From: Sue Howell
Sent: 06 September 2018 14:52
To: Planning.Responses
Cc: Michael Eastham
Subject: RE: Planning Consultation on BN/35/18/DOC

Comment from Greenspace

APPLICATION BN/35/18/DOC

Site Address: Land at former Pollards Nursery Lake Lane

DATE: 31/07/2017
REF: 1707.16693(BarnhamLeap_RedrowHomes)

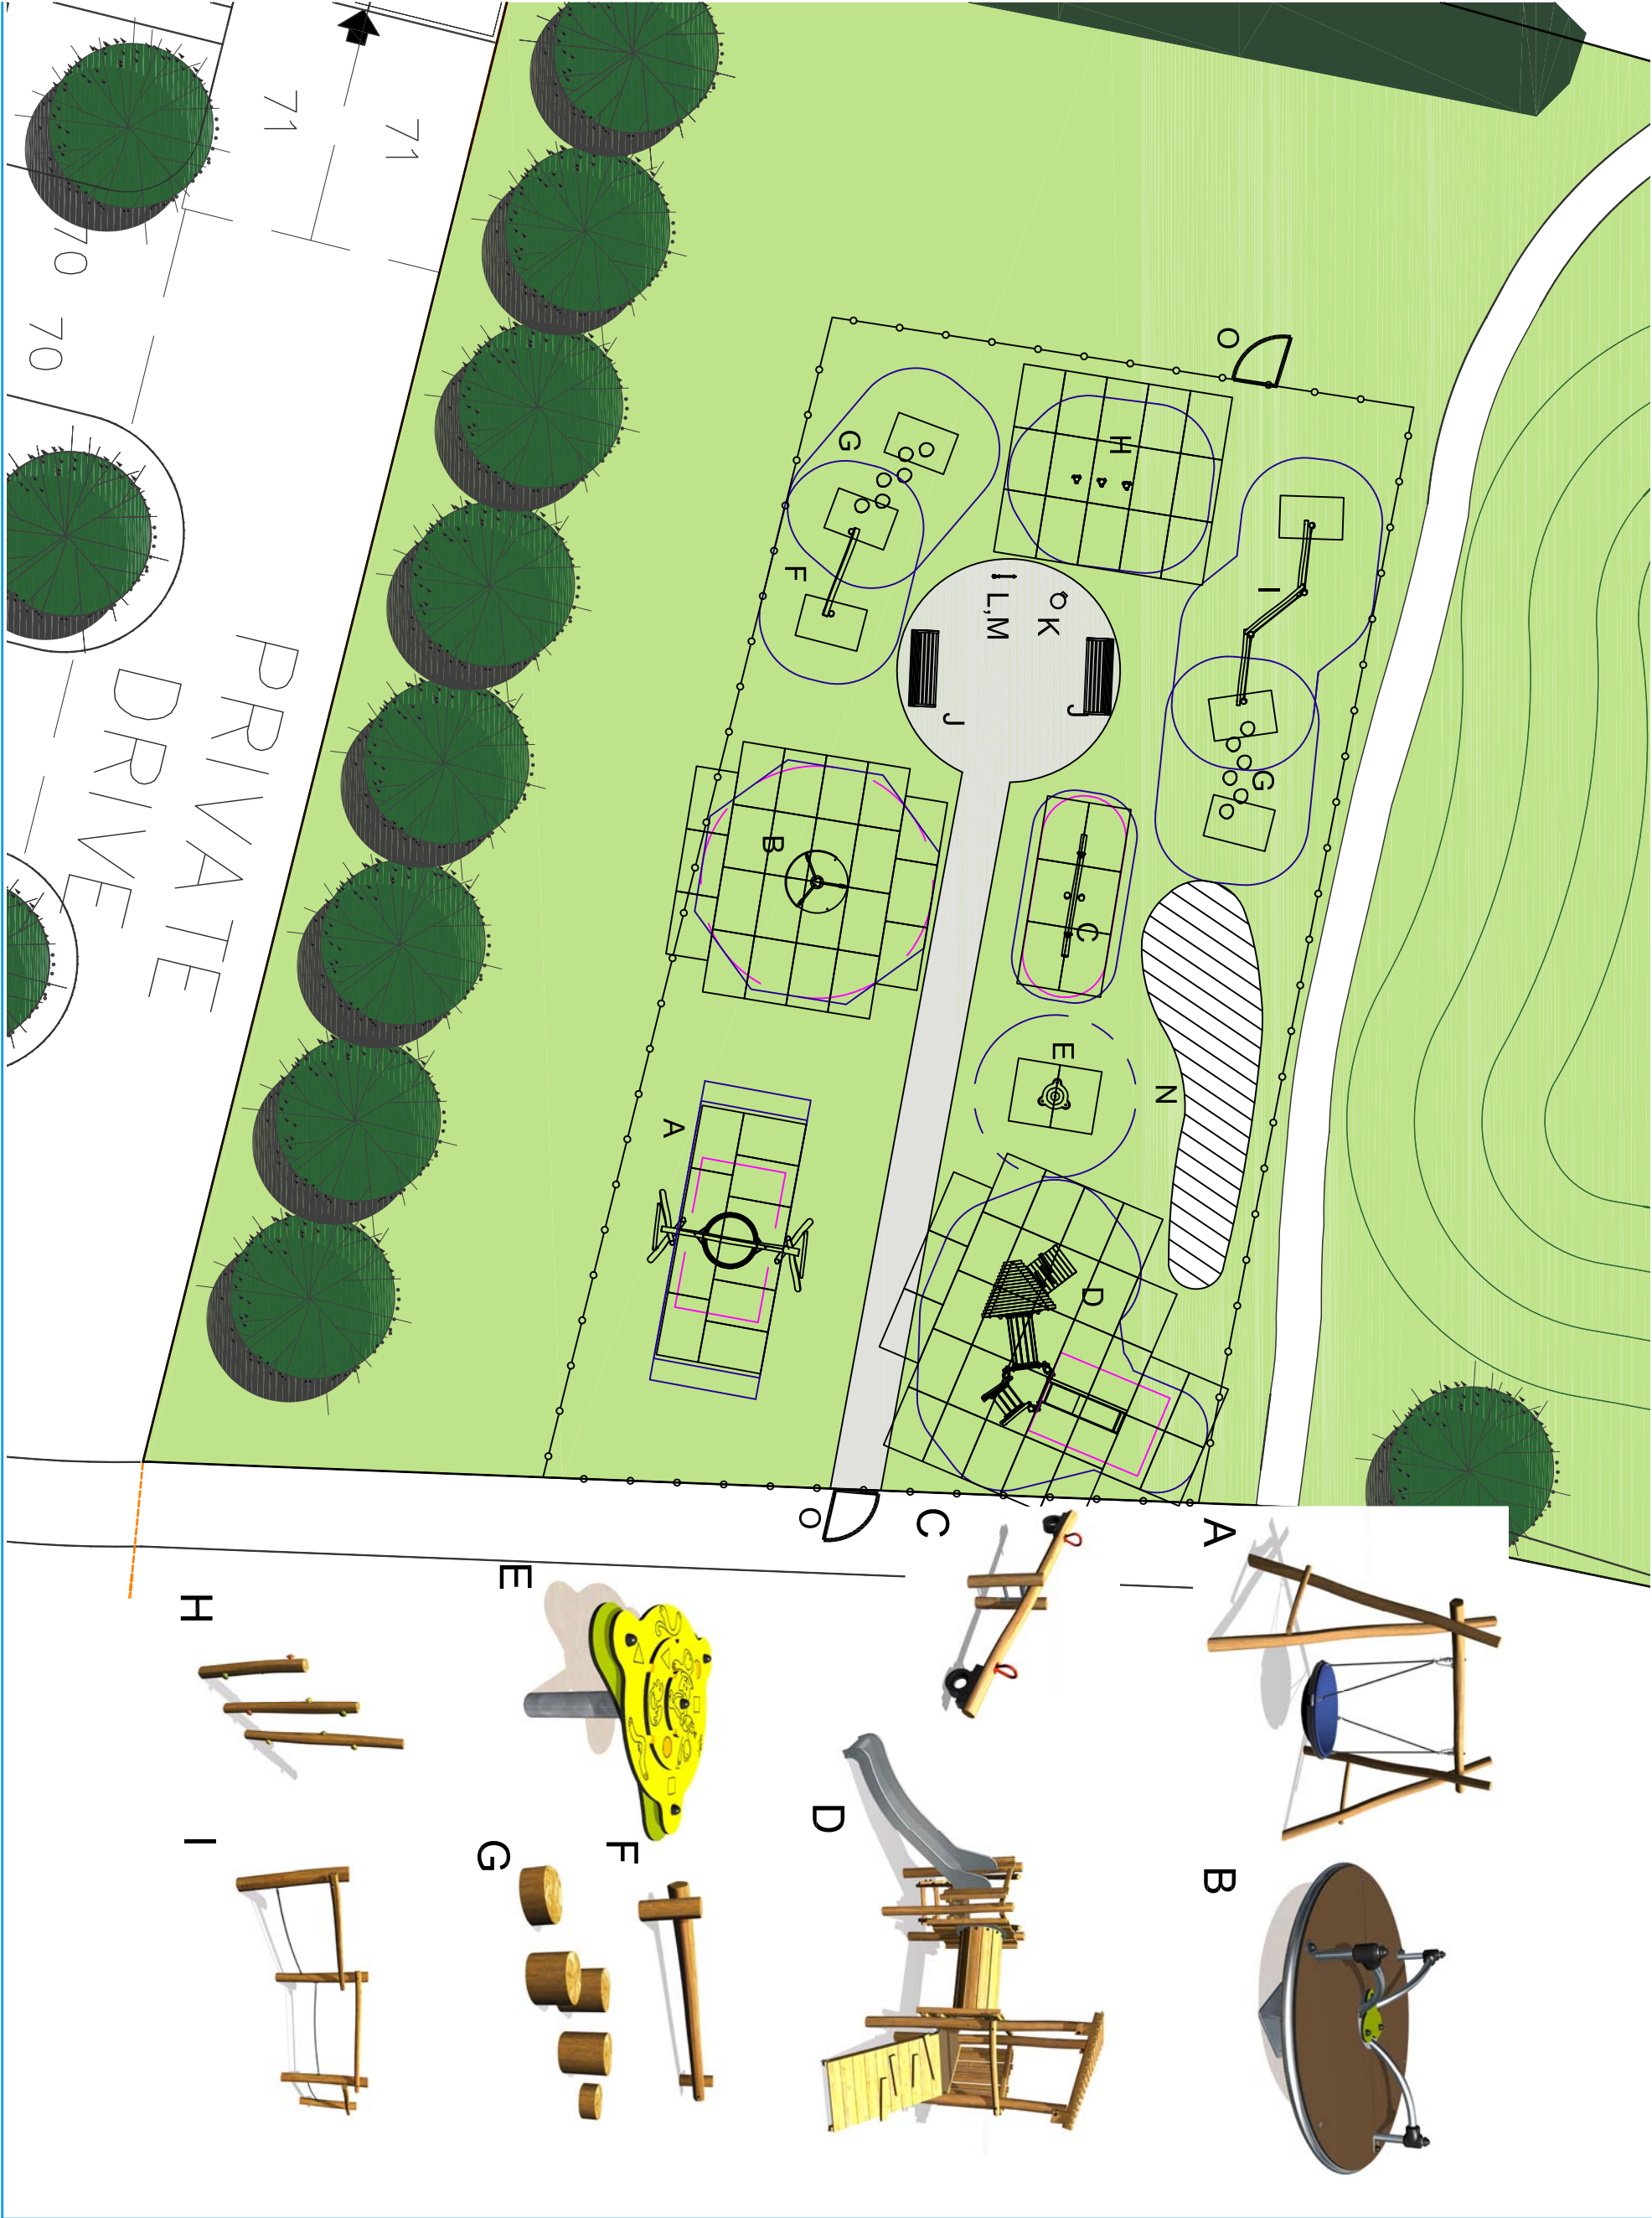
Also details contained within drawing ref 1707.16693 (Barnham Leap Redrow Homes) drawing provide confirmation of play offer being proposed with equipment, surfacing, fencing, gates and ancillaries, which are considered to be adequate and therefore advise that I would **recommend the discharge of Condition 12 P.O.S** imposed under planning permission BE/16/12 on this application BN/35/18/DOC
